Job ID: 2012-10-5119-ALTR

has permission to 18' x22' Add, 24' x24' Garage w/ mudroom Int Reno

Jonathan Rioux - Re: 6 Goveside

MAP # 1B2
 LOT # 25
 SCALE: 1" = 10'

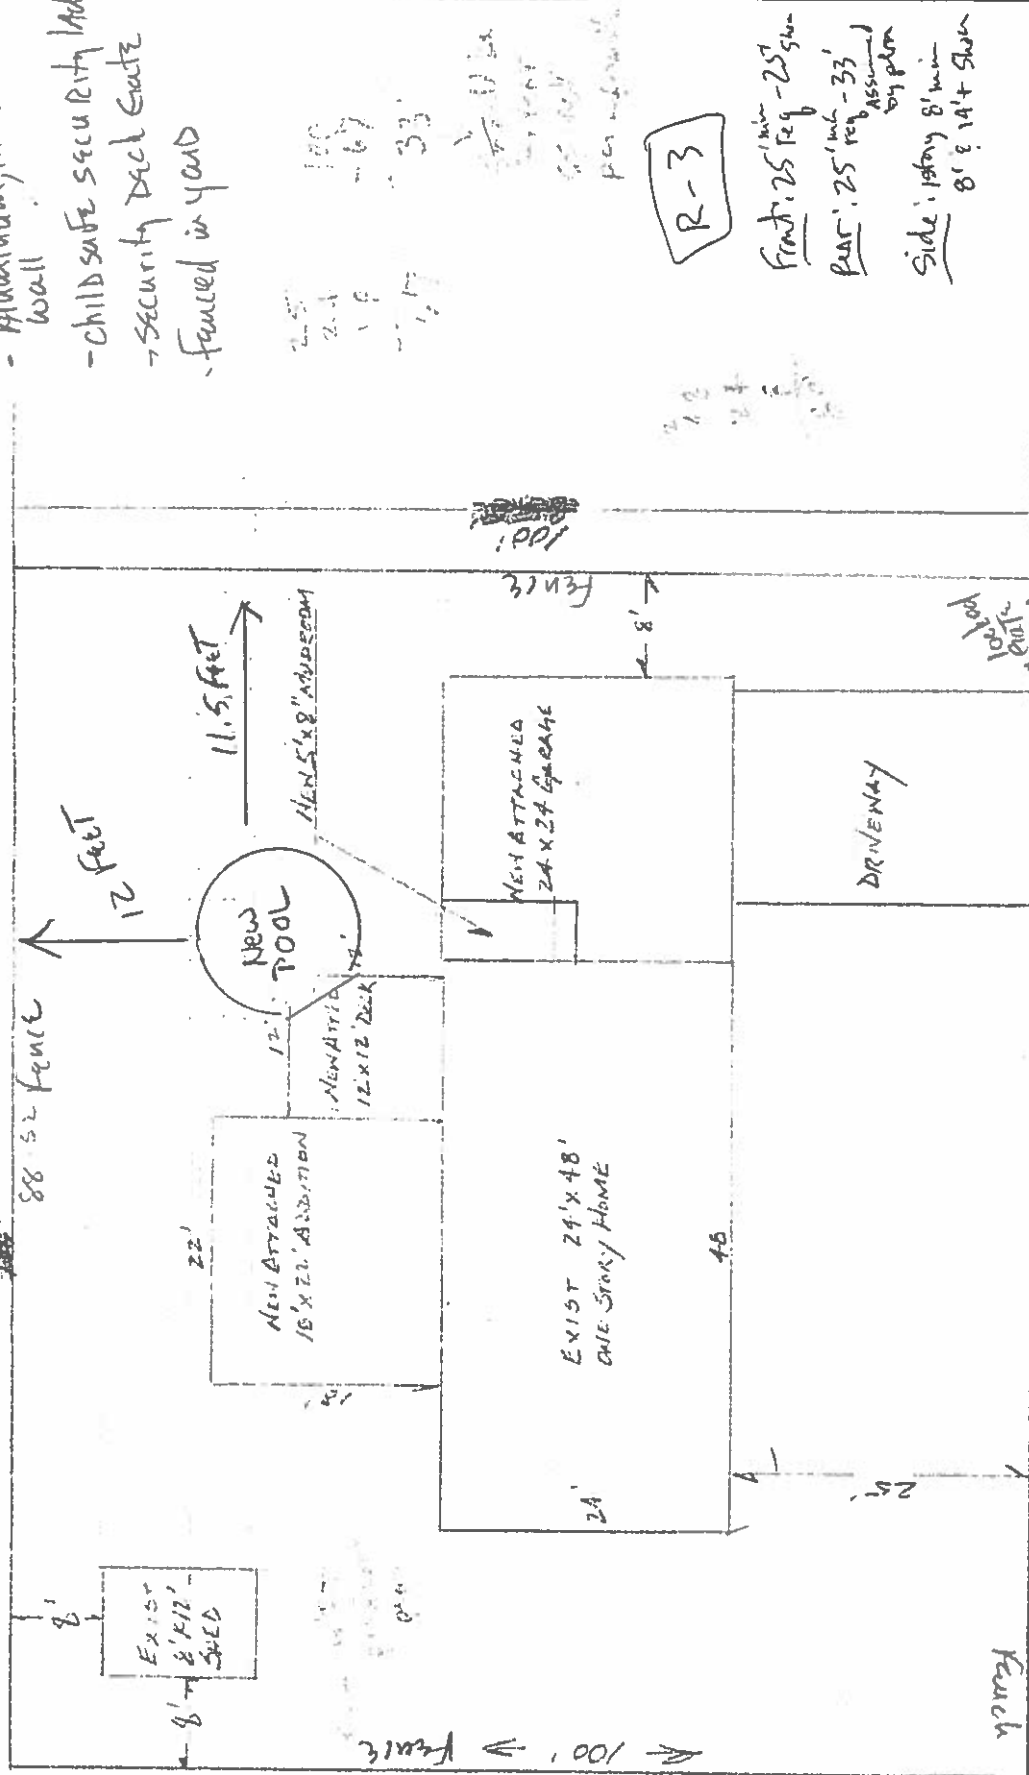
100
- 67
33'
↓
should be
the REAR
set back
per information

Front: 25' min req - 25' show
Rear: 25' min req - 33' assumed by plan
Side: 1st story 8' min 8' & 14'+ show
